DRB CASE ACTION LOG (SITE PLAN B.P.)

DRB Application No.: 05DRB-01051 (SBP)
Project Name: JOURNAL CENTER, PHASE 2
Agent: Claudio Vigil Architects

DEVELOPMENT REVIEW BOARD
TRANSPORTATION DEVELOPMENT
Standard Comment Sheet

DEVELOPMENT REVIEW BOARD--SPEED MEMO

SHEET
SP-1
 PROJECT NUMBER

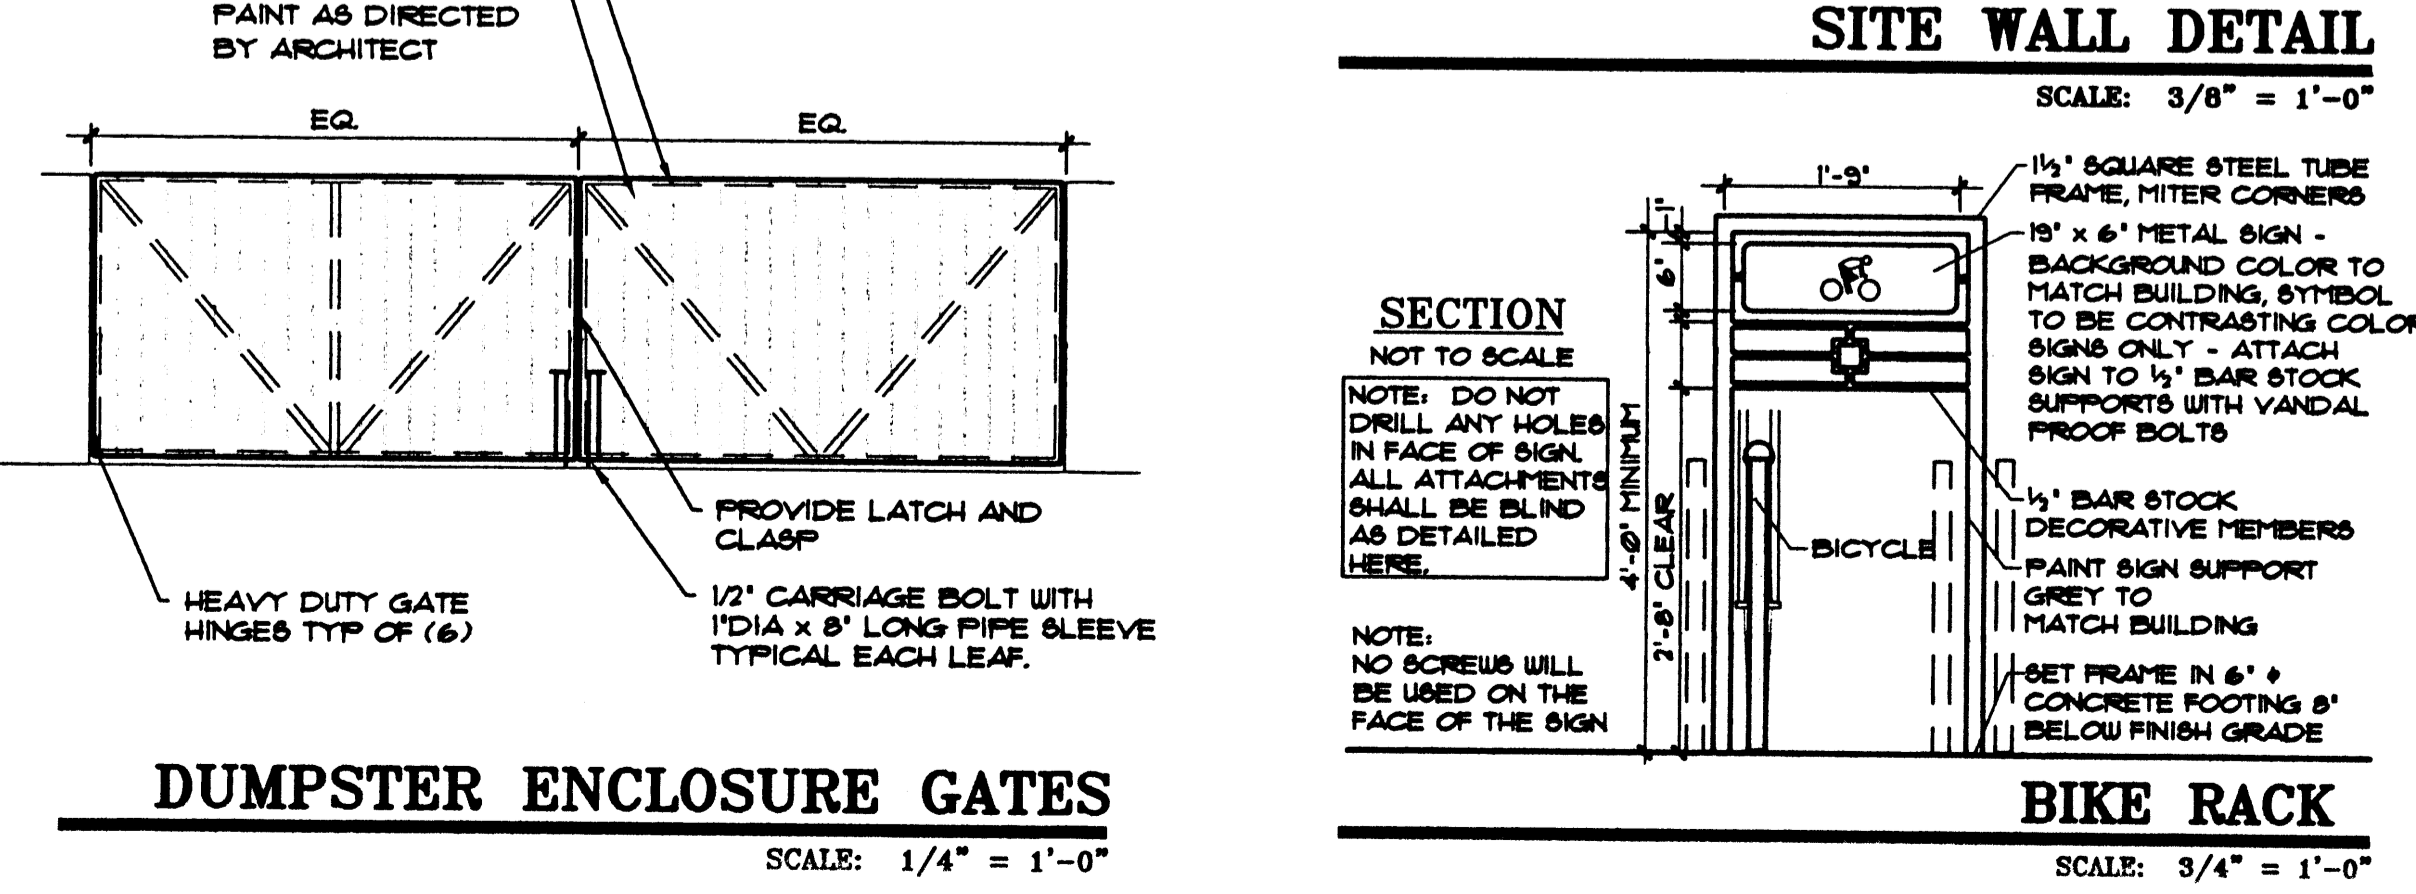
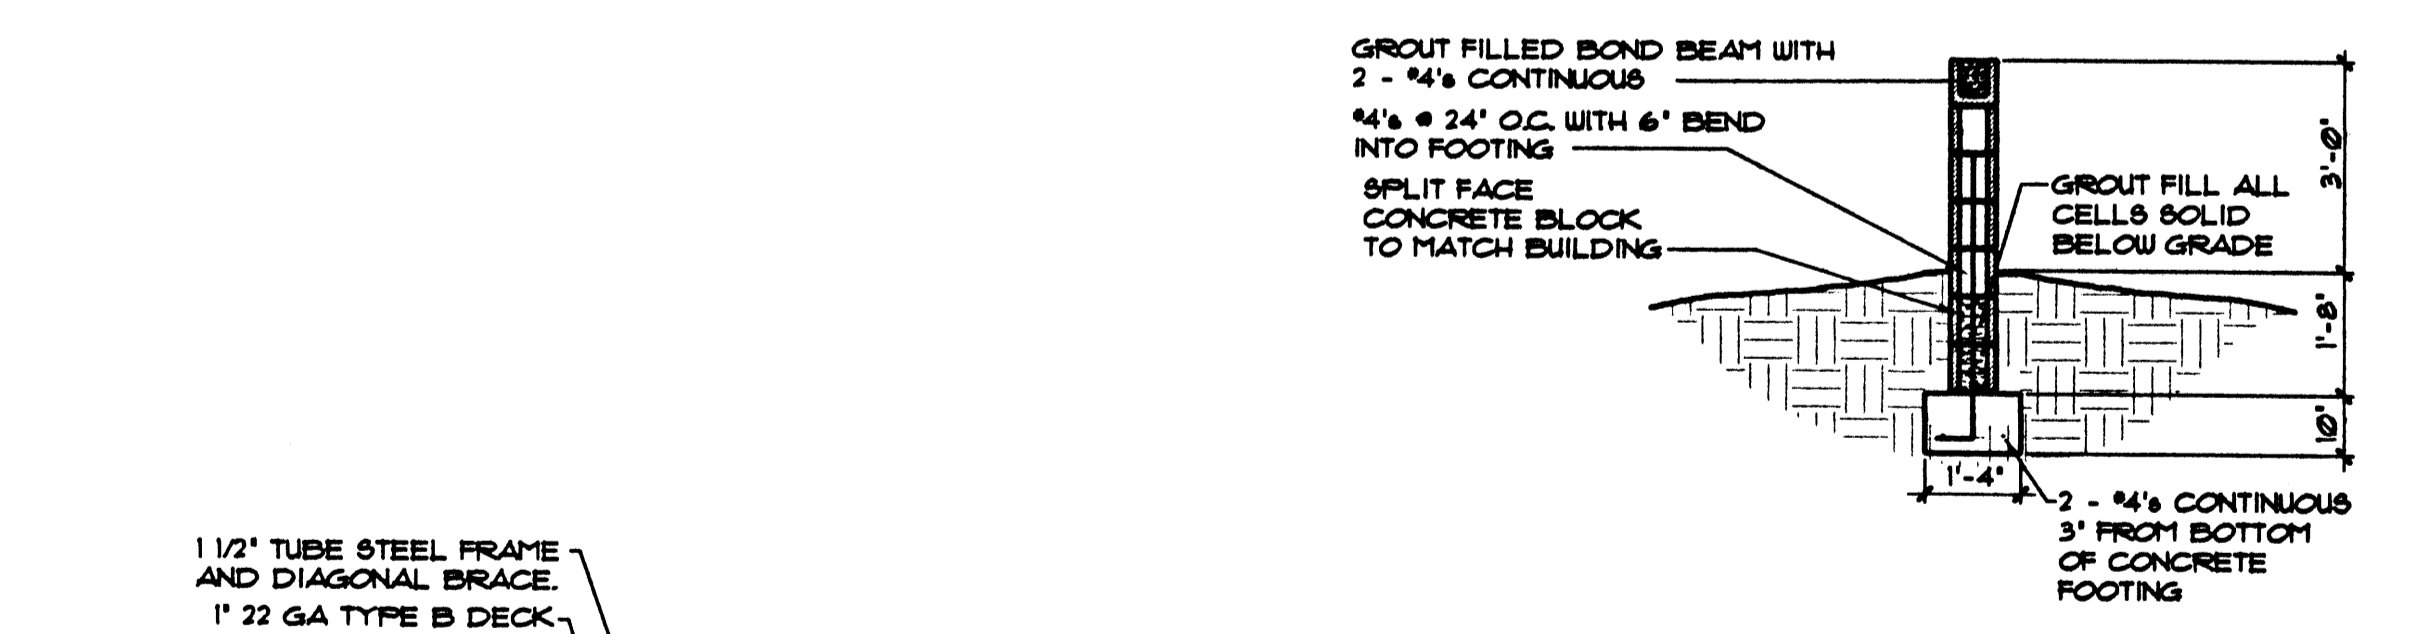
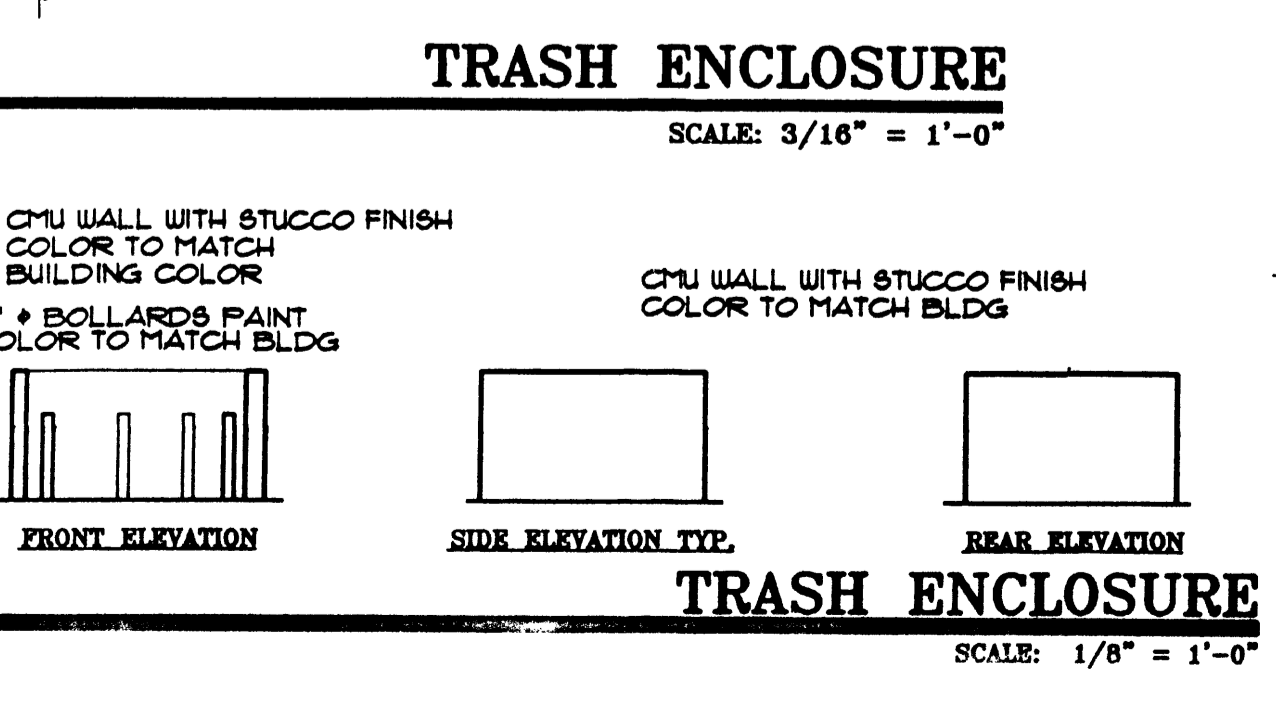
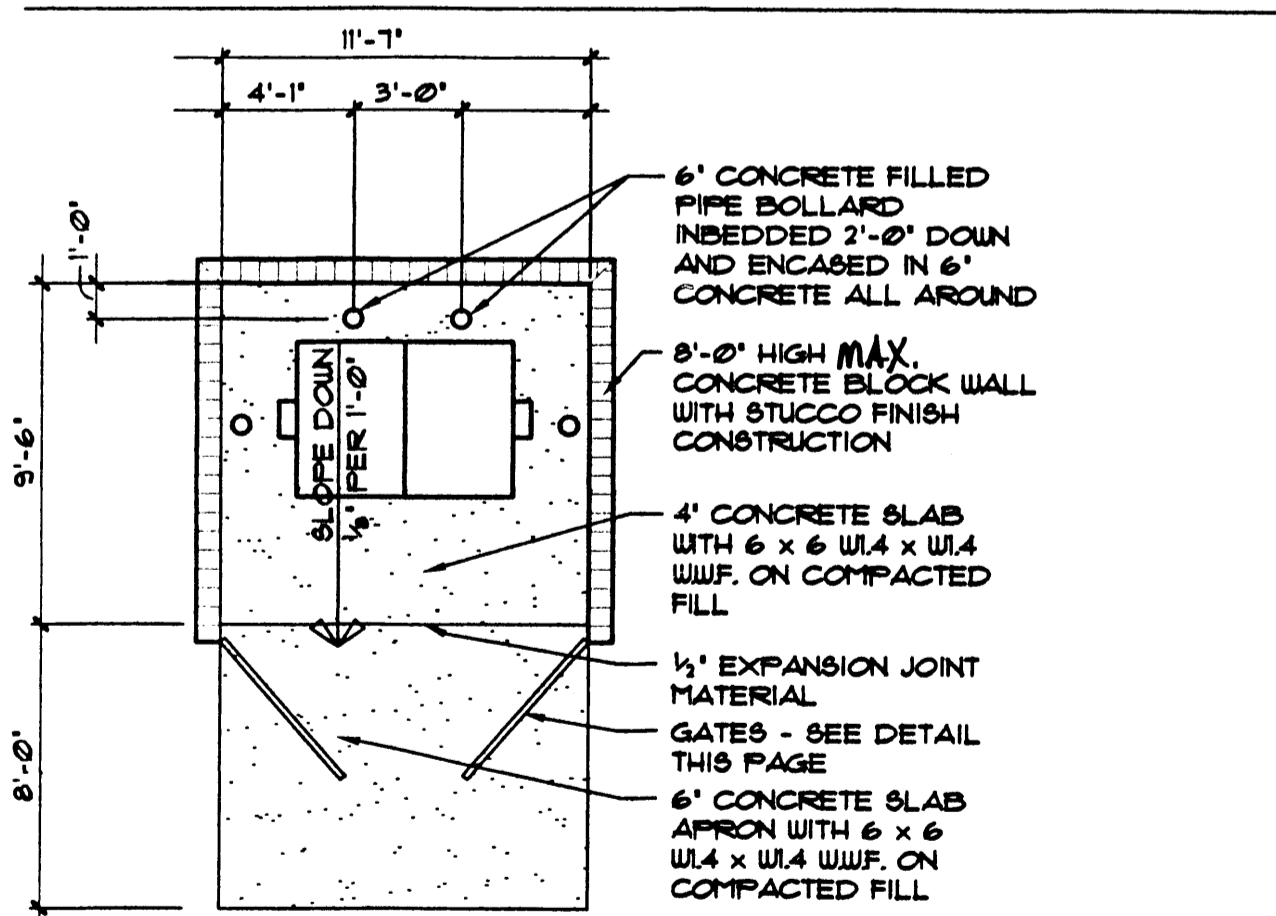
<u>No.</u>	<u>Comment</u>
1)	ADA aisle must be either 8' or 5'.
2)	What is width of proposed sidewalk?
3)	What are the widths of the new drivepads?
4)	Are there any drive located across the street?
5)	Use a 25' radius at the east entrance.

CONCEPTUAL UTILITY PLAN

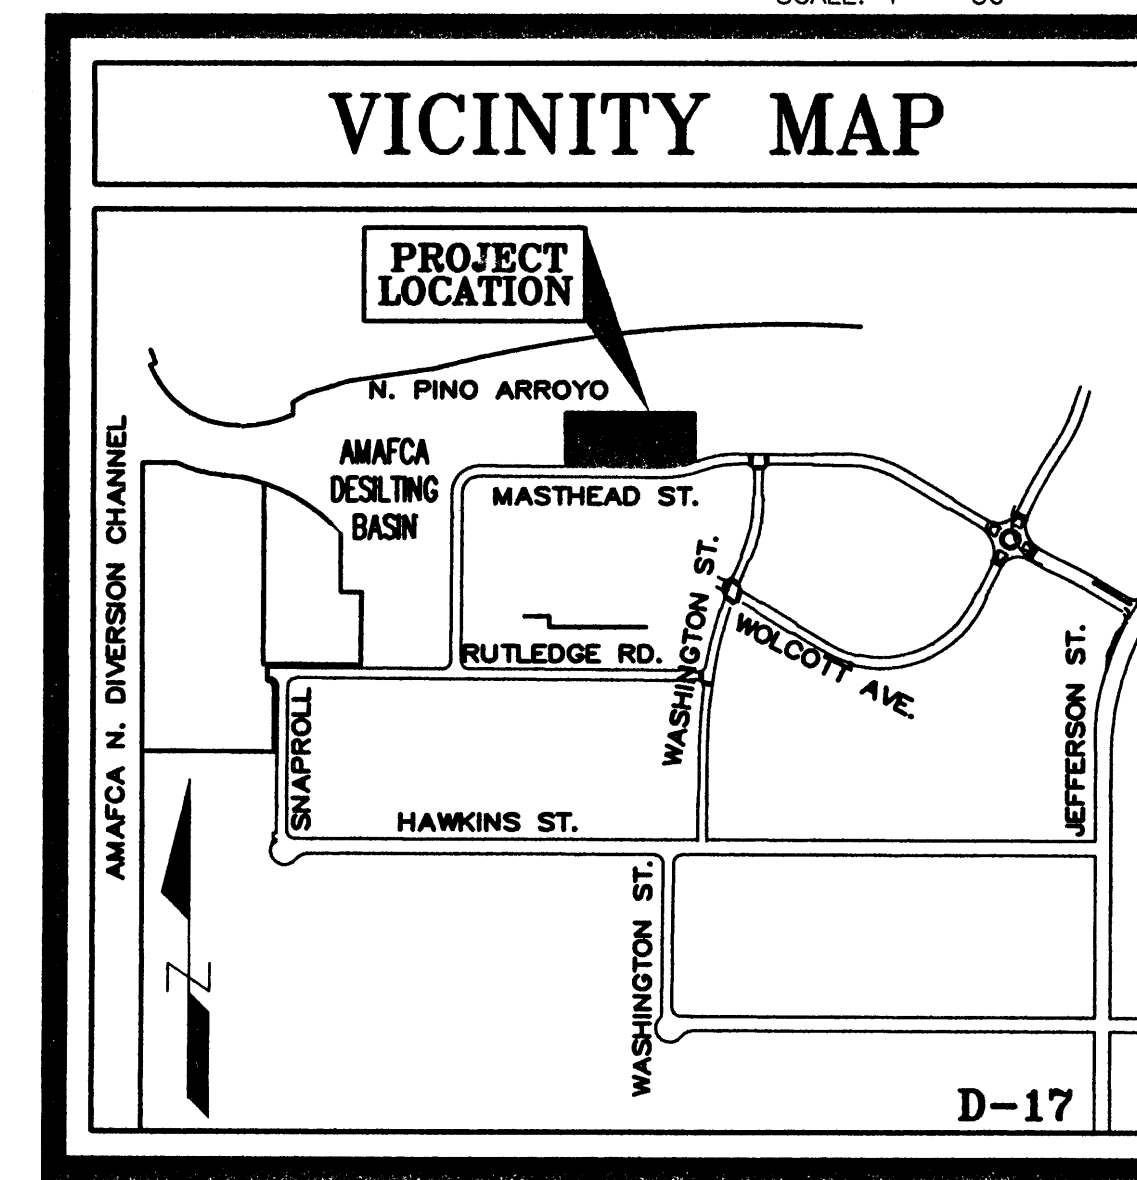
UTILITIES: Revise Utility Plan to Match "AS-BUILT" Conditions.
